Rezoning Transportation Analysis

Petition Number: 2021-125

Date	Description
09-17-2021	First Review (WLB)
11-22-2021	Second Review (AO)
01-25-2022	Third Review (AO)

RZ-1.0

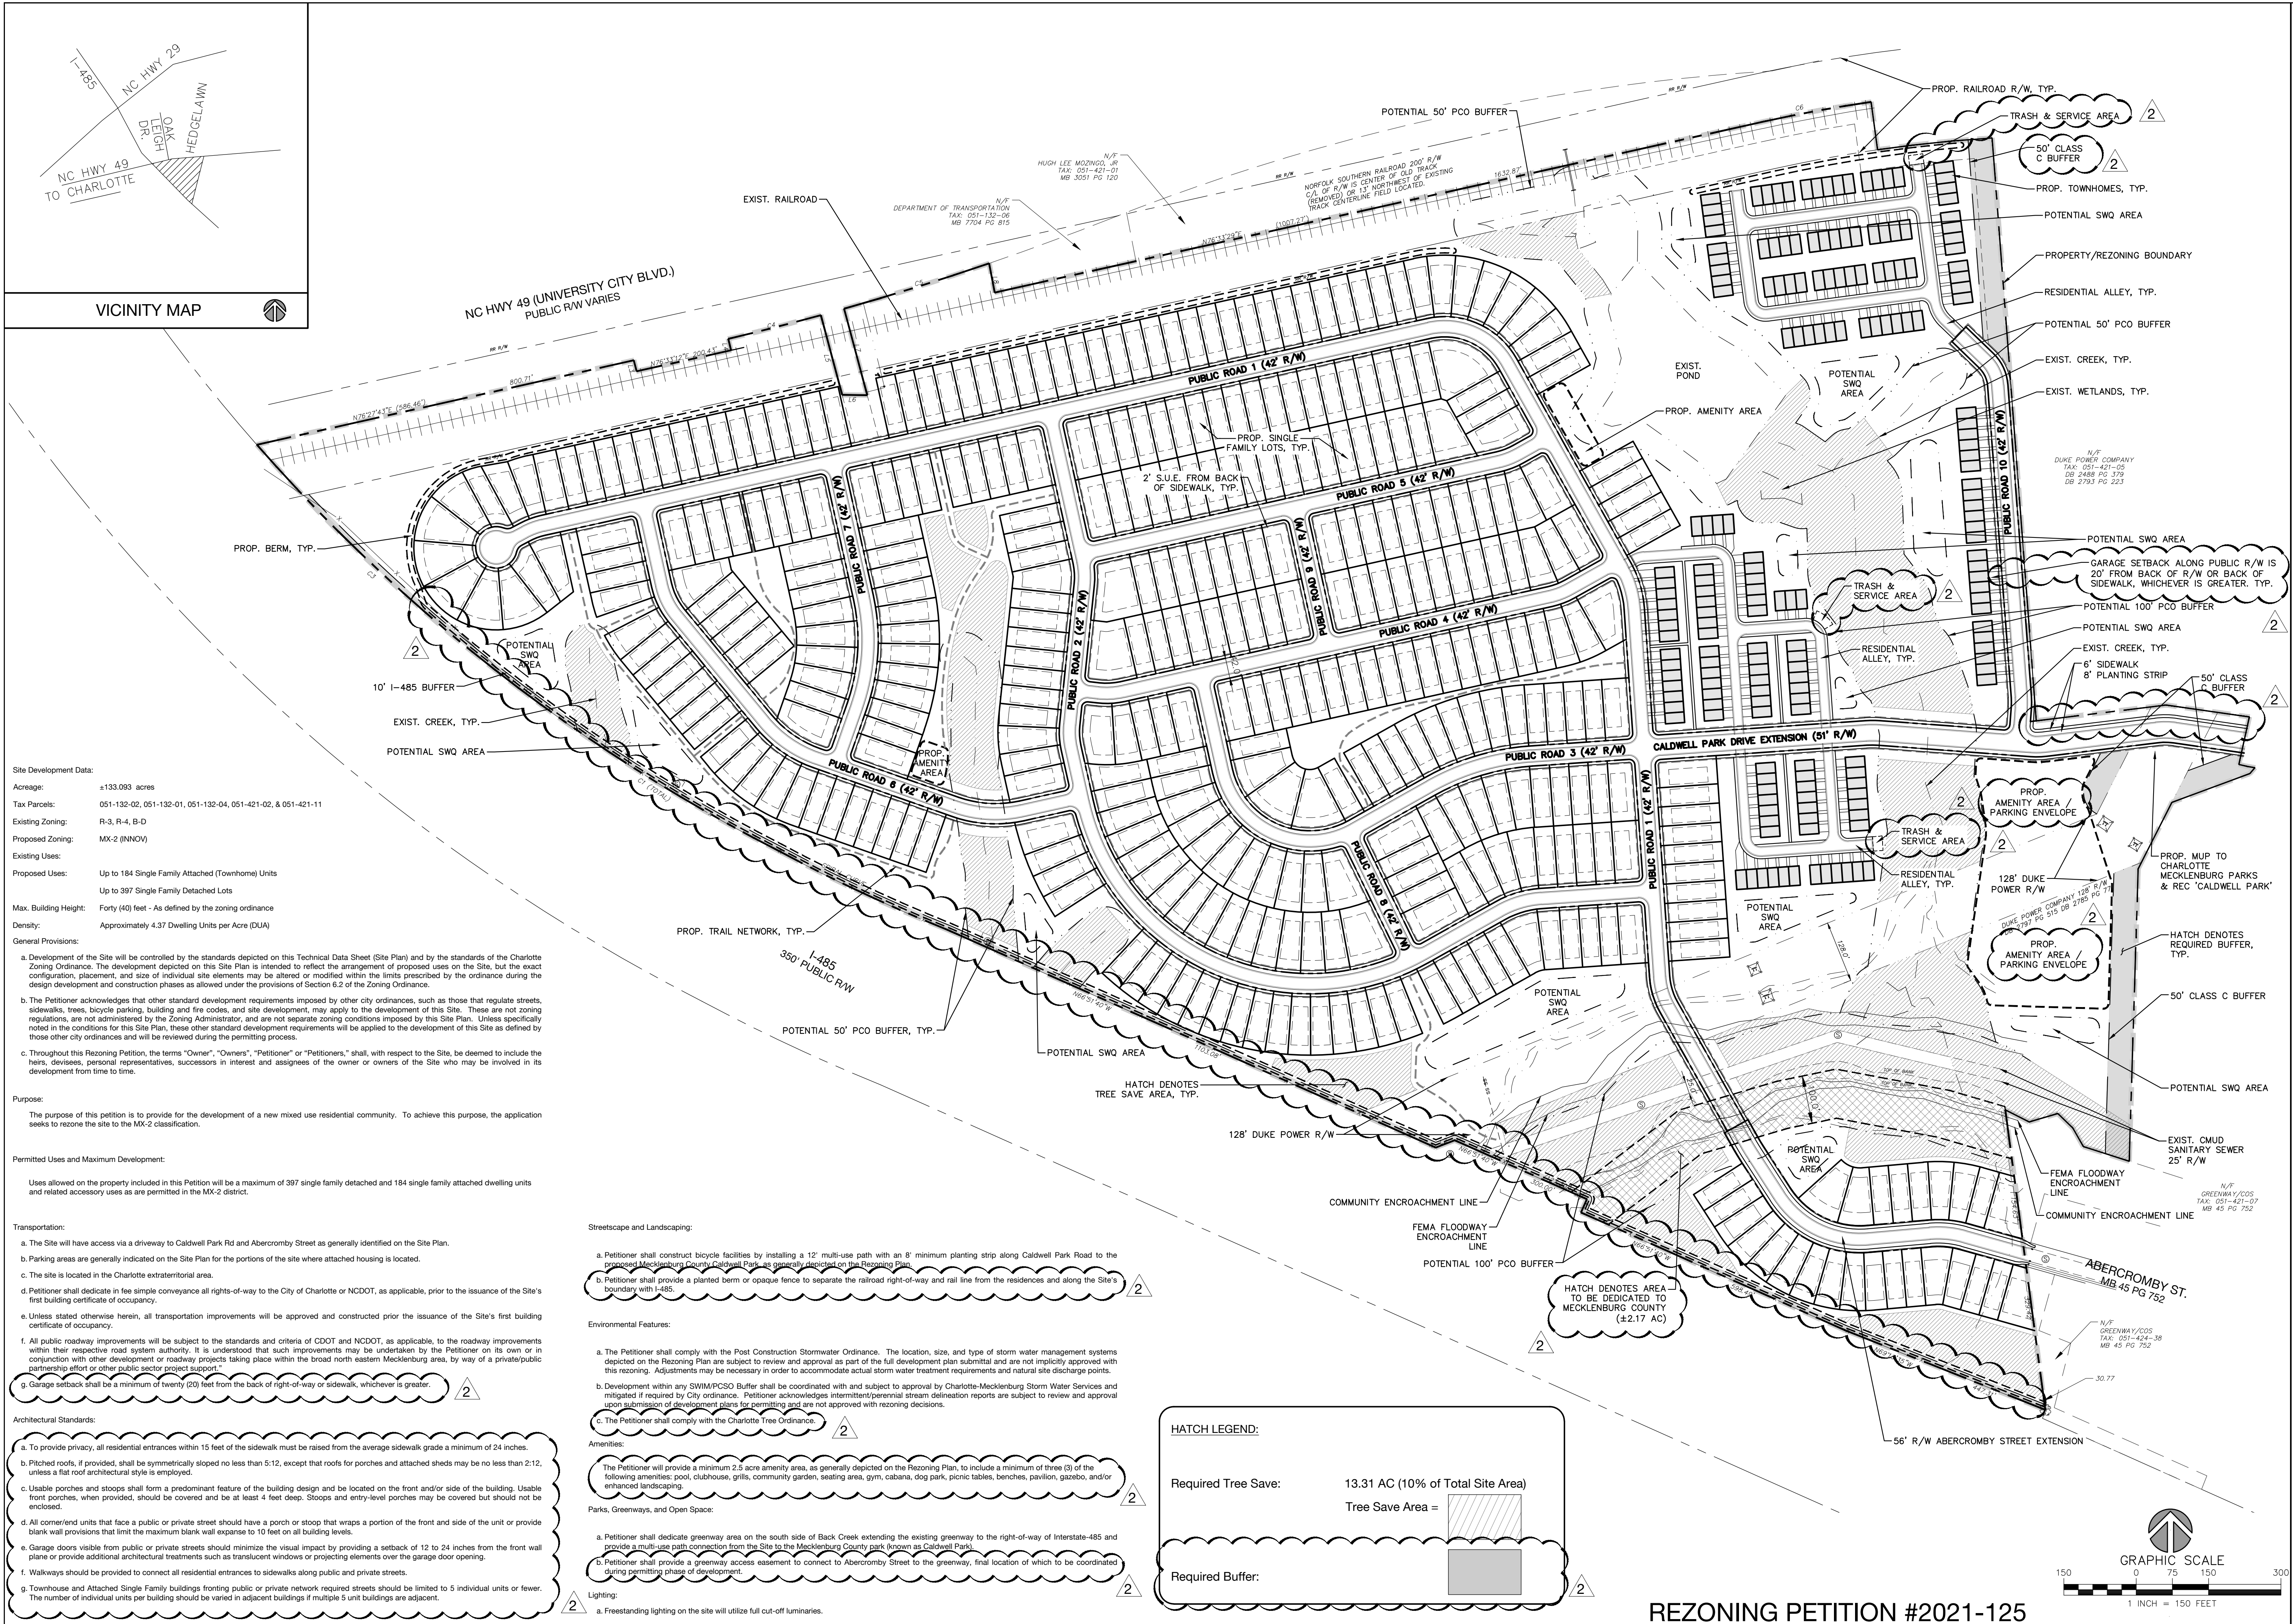
9. **New Comment (New Site Plan:1-17-22):** Site plan and conditional note(s) revisions are needed to identify exact location and limits of multi-use path along Caldwell Park Road.

10. **New Comment (New Site Plan:1-17-22):** Add conditional note(s) committing to extend Caldwell Park Drive to proposed Public Road 1 as depicted on site plan per the Subdivision Ordinance.

11. **New Comment (New Site Plan:1-17-22):** Site plan and conditional note(s) revisions are needed to commit to the construction of noise walls or tall fencing (with no gates) between the railroad right-of-way and the home lots that back to the railroad. The wall/ fencing should be placed within open space to allow for the HOA to maintain it.

12. **New Comment (New Site Plan:1-17-22):** Site plan and conditional note(s) revisions are needed to commit to the construction of noise walls between the I-485 right-of-way and the home lots that back to I-485. The wall should be placed within open space to allow for the HOA to maintain it.
